Rezoning Transportation Analysis

Petition Number: 2022-187

Date	Description
3-22-23	First Review (IW)
4-20-23	Second Review (IW)

The site is adjacent to Krefeld Drive, a City-maintained minor throughfare, and south of East Independence Boulevard, a State-maintained expressway. A Traffic Impact Study (TIS) is not required for this site. The development has committed to the dedication of right-of-way. CDOT has no outstanding issues.

**RZ-1.0**

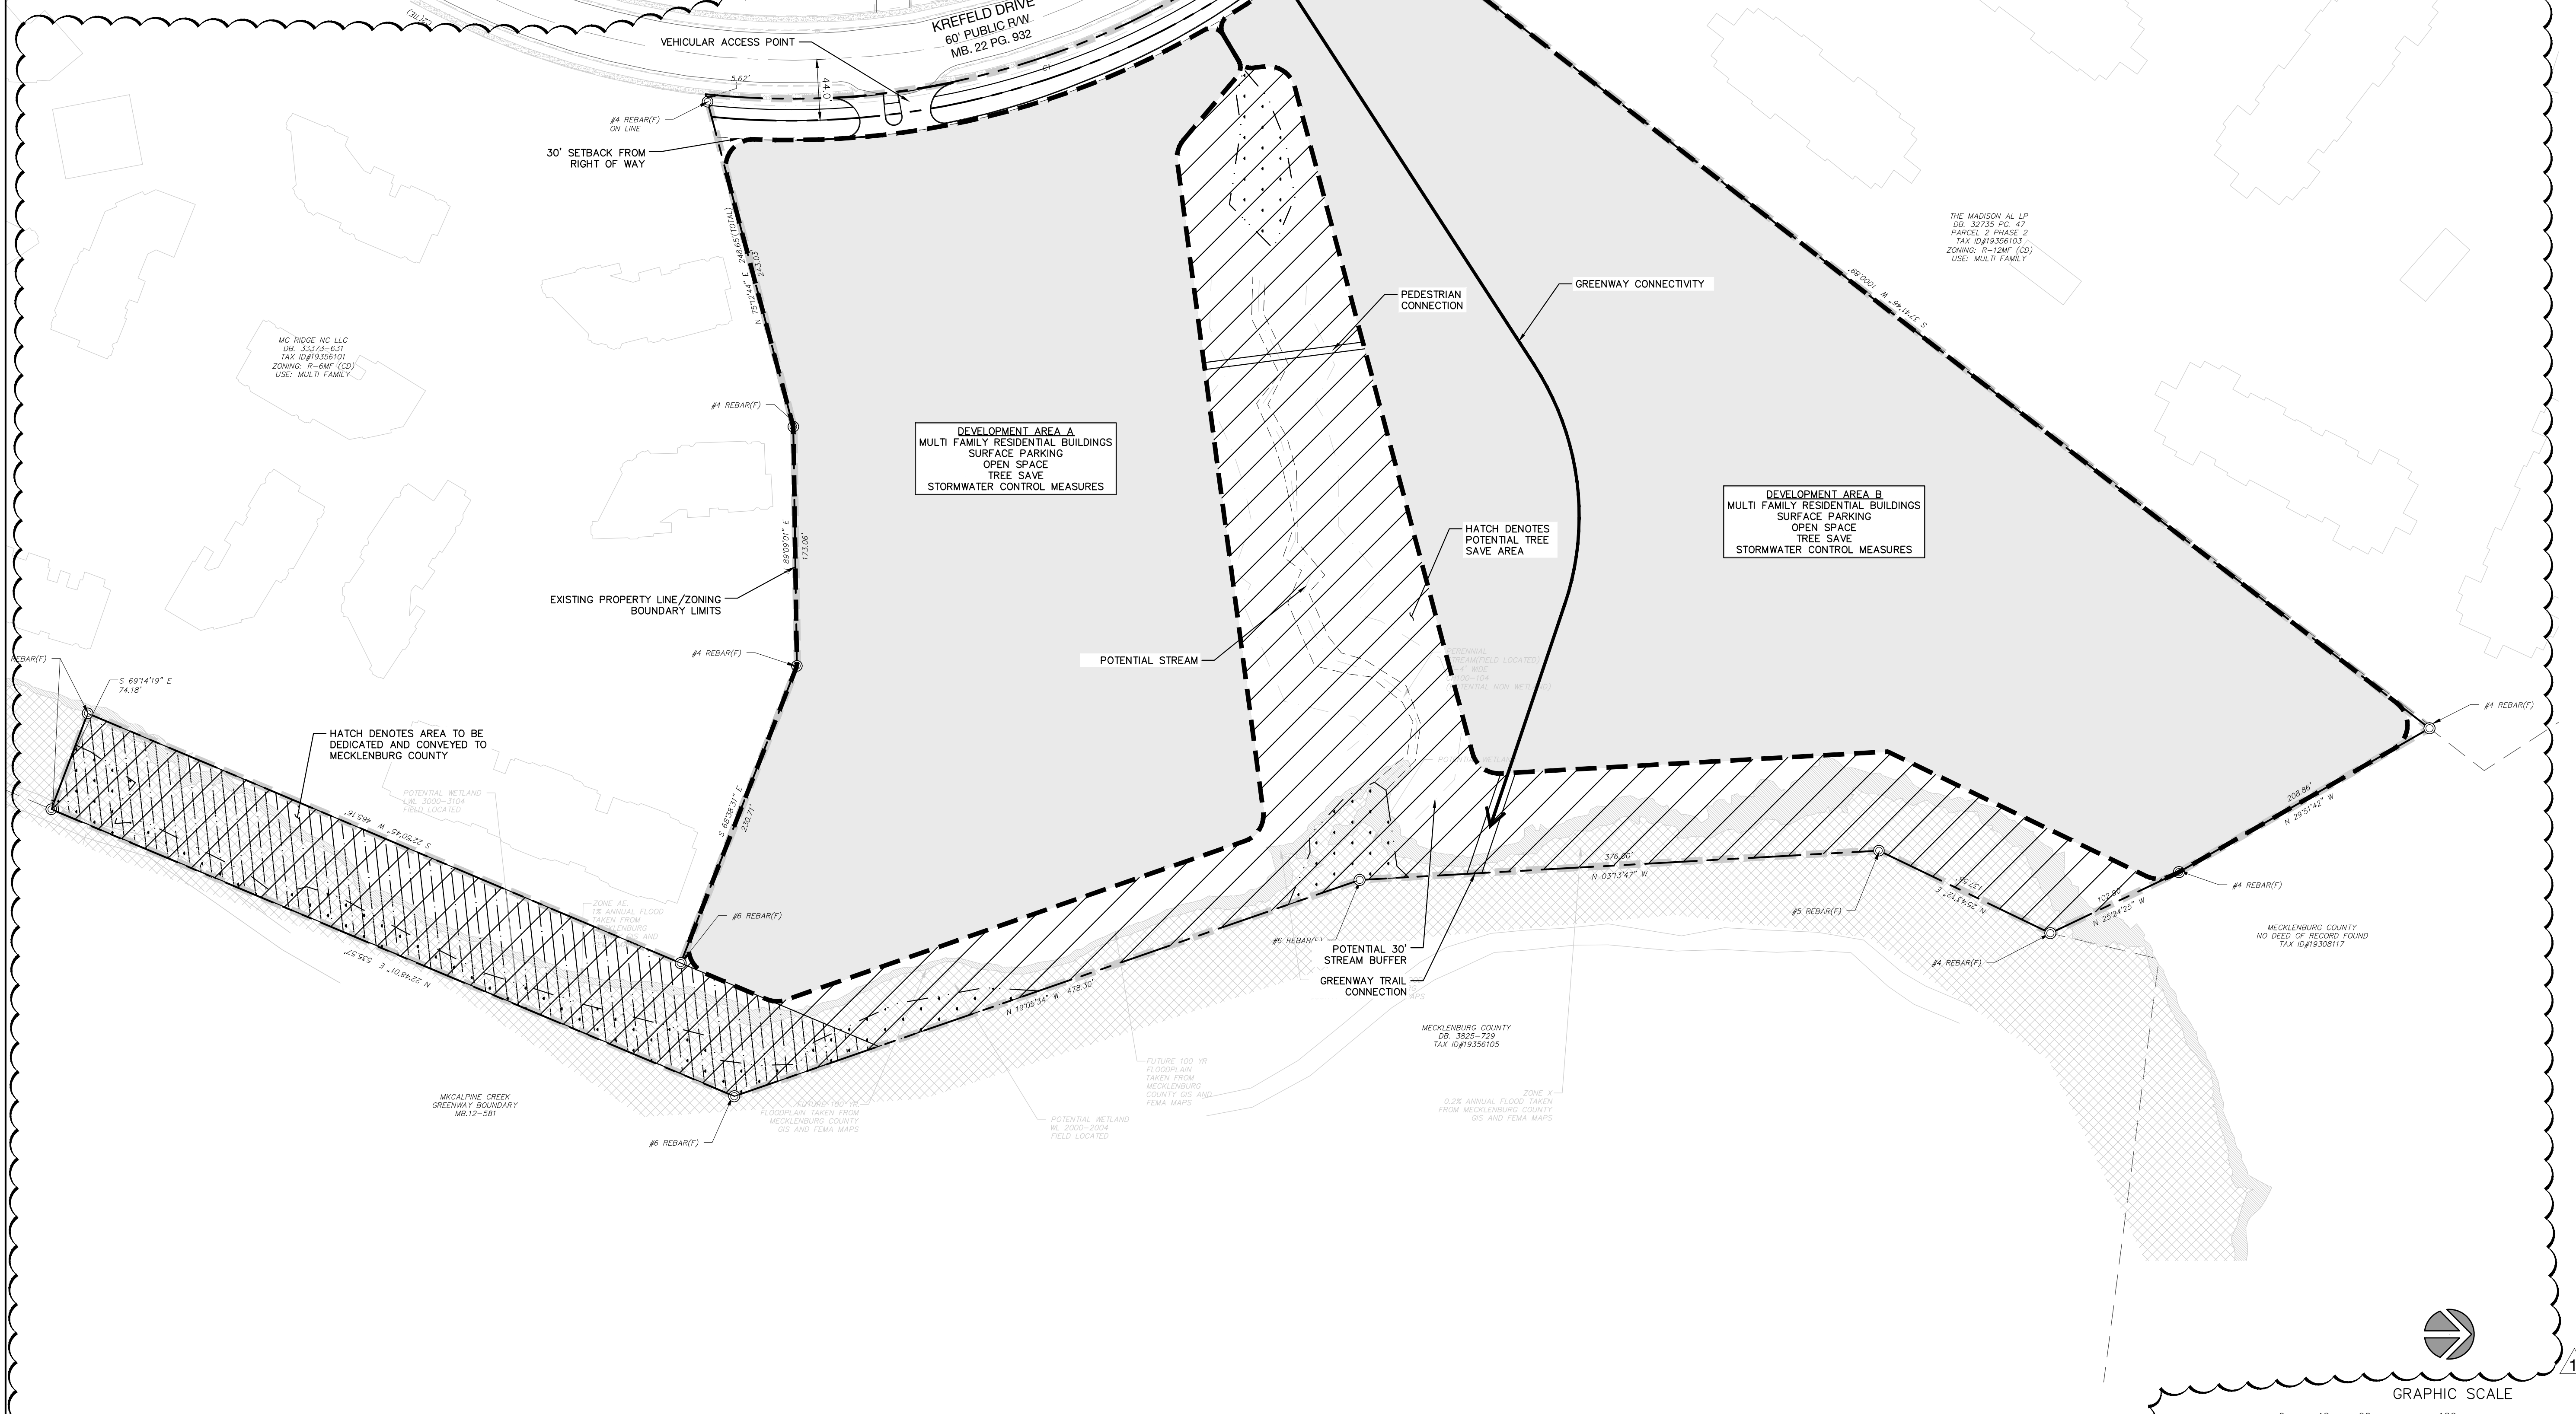
- a. ~~Krefeld Drive: CDOT requests the location of curb and gutter to be moved to 24 feet from roadway centerline to accommodate the Charlotte Streets Map with a roadway typical section of 2+ Avenue with bike lanes.~~

~~Label and dimension the curb and gutter from the centerline for each road on the site plan.~~

3. ~~Revise site plan and conditional note(s) to commit to dedicate 40' of right-of-way from the road centerline. The site plan shall label and dimension the right of way from the road centerline.~~

4. ~~Outstanding comment from 3-22-23: Revise site plan and conditional note(s) to commit to construct bicycle facilities by locating the curb and gutter 24' from the center line to meet the Council-adopted Charlotte BIKES Policy and to support Council-adopted Charlotte Streets map.~~

6. ~~CDOT Request: Revise site plan and conditional note(s) to commit to creating a full public access greenway connection from Krefeld Drive to connection shown on site plan and extending to existing greenway behind property if developer is given real estate or permission to construct by Mecklenburg County.~~
